APPROVED
 Limited building only review
 Permit holder responsible for full compliance with the code.

CUSTOM BUILT FOR: JAMES JR. & ATAYONNA BARNES
 JOB #: DUTCOO 021 0840 CN #: 32391 VN #: BA262
 LOCATION: 1092 OLD STAGE RD.
 ERWIN, NC 28333
 COUNTY: HARNETT

BEVERLY AMERICAN TRADITION / CUSTOM
 FOUNDATION PLAN

DATE: 9/17/2021
 DRAIN BY: SG
 SCALE: 1/8" = 1'-0"
 DRAWING: 3

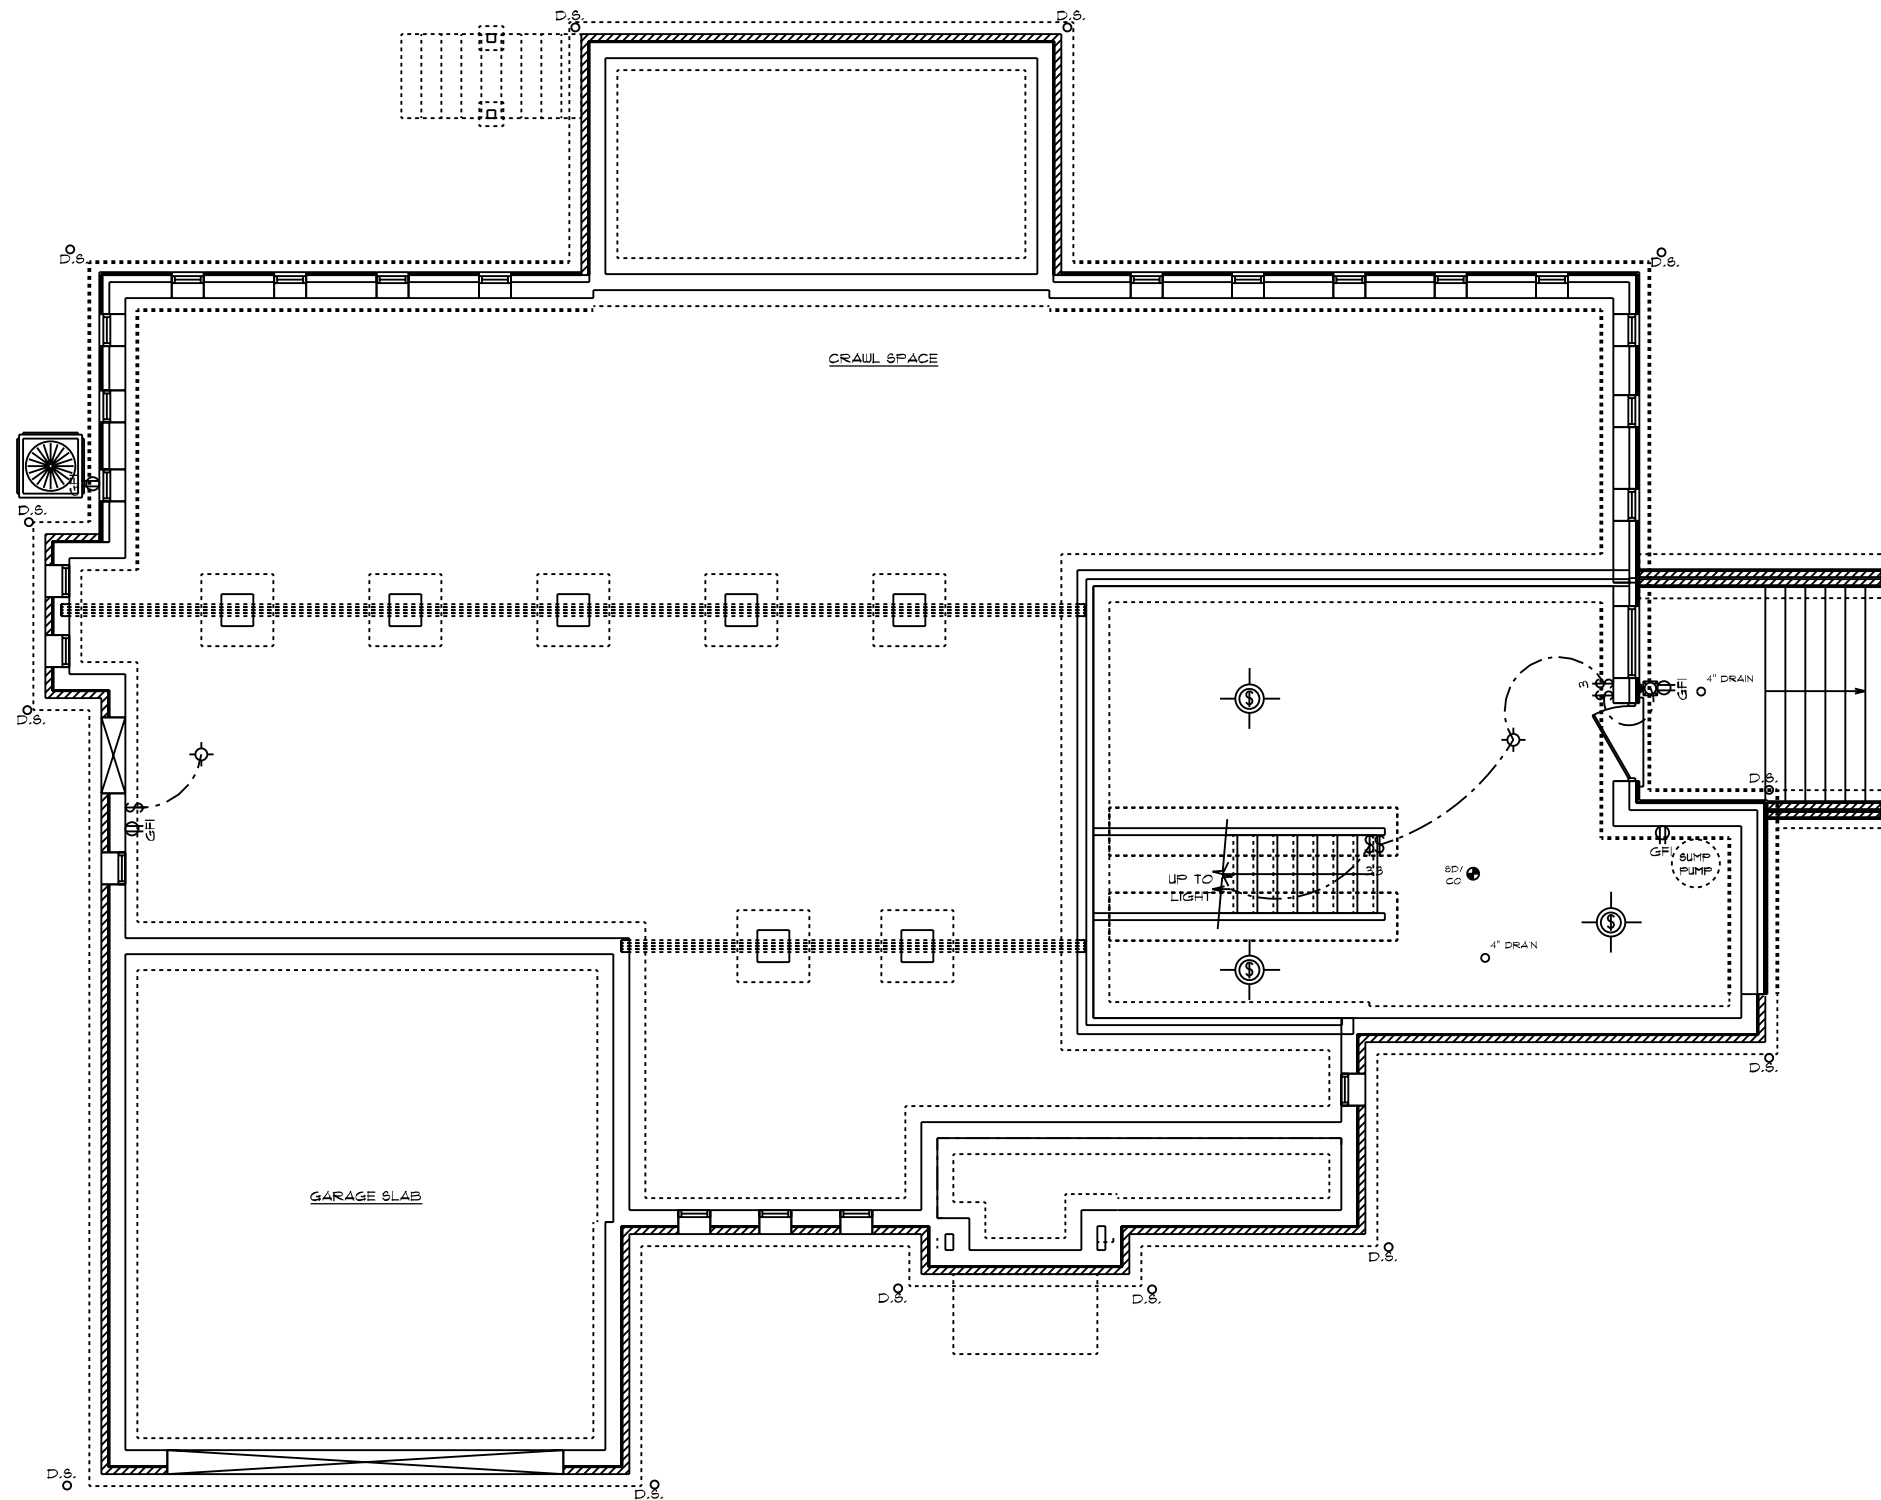
Field verify unbalanced fill and continuous footings

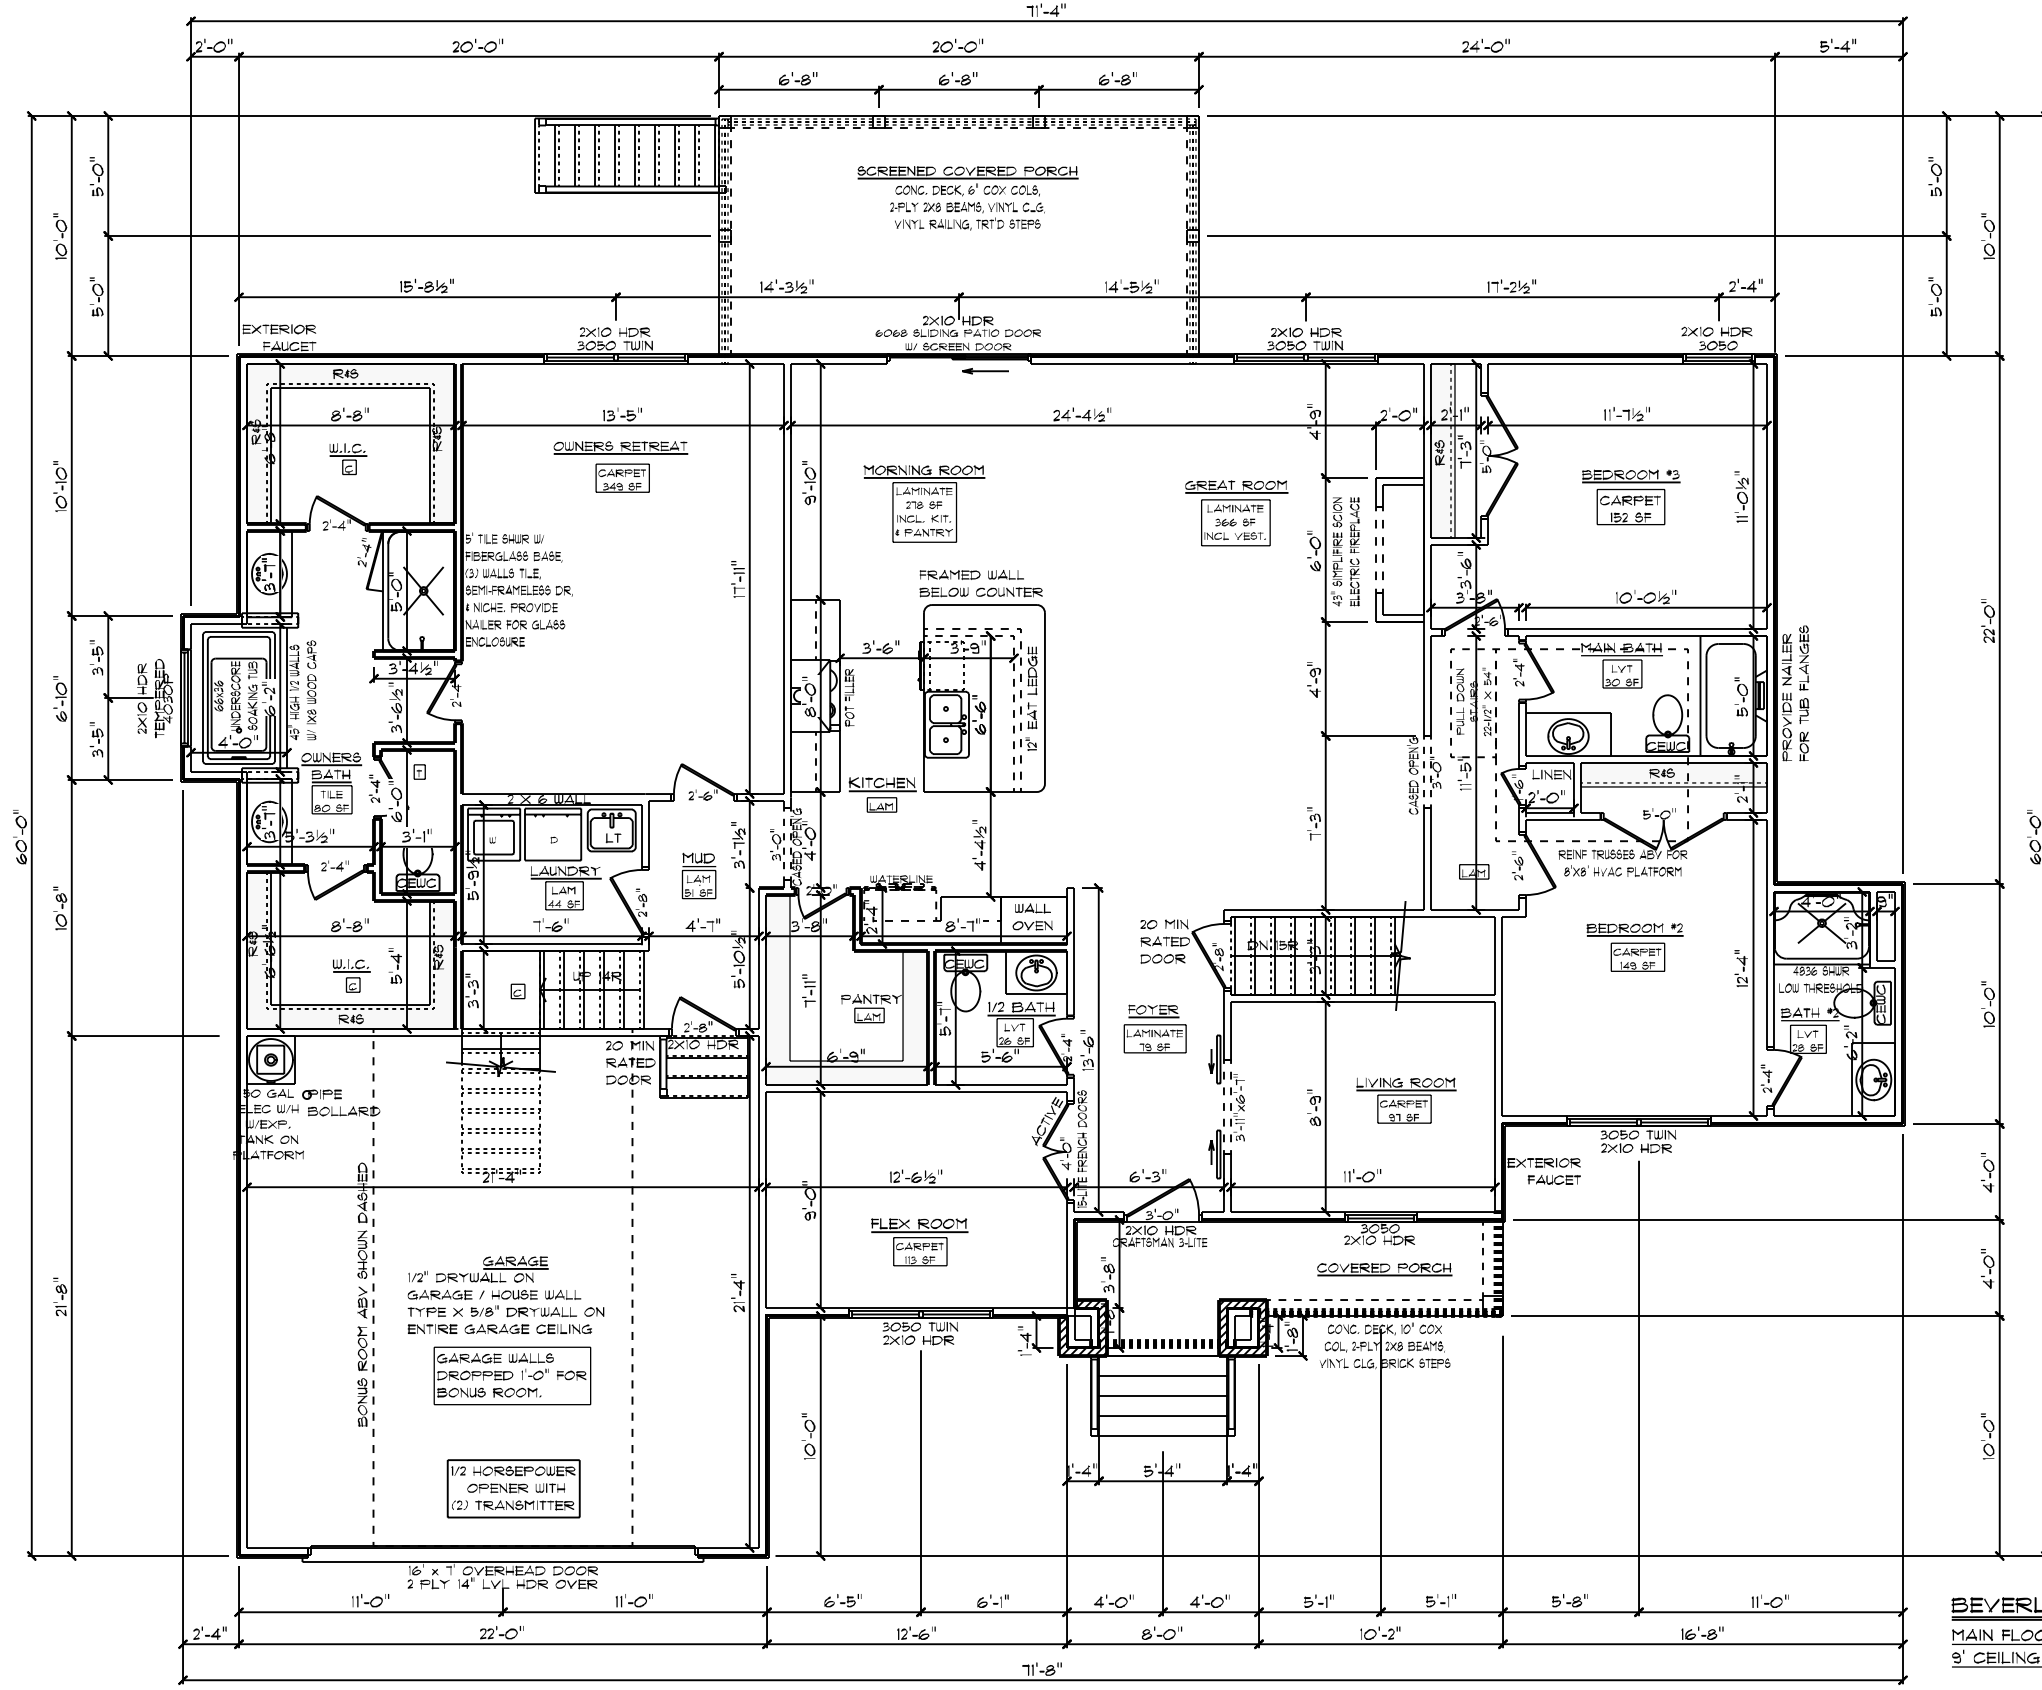
Max span 19'. Field verify
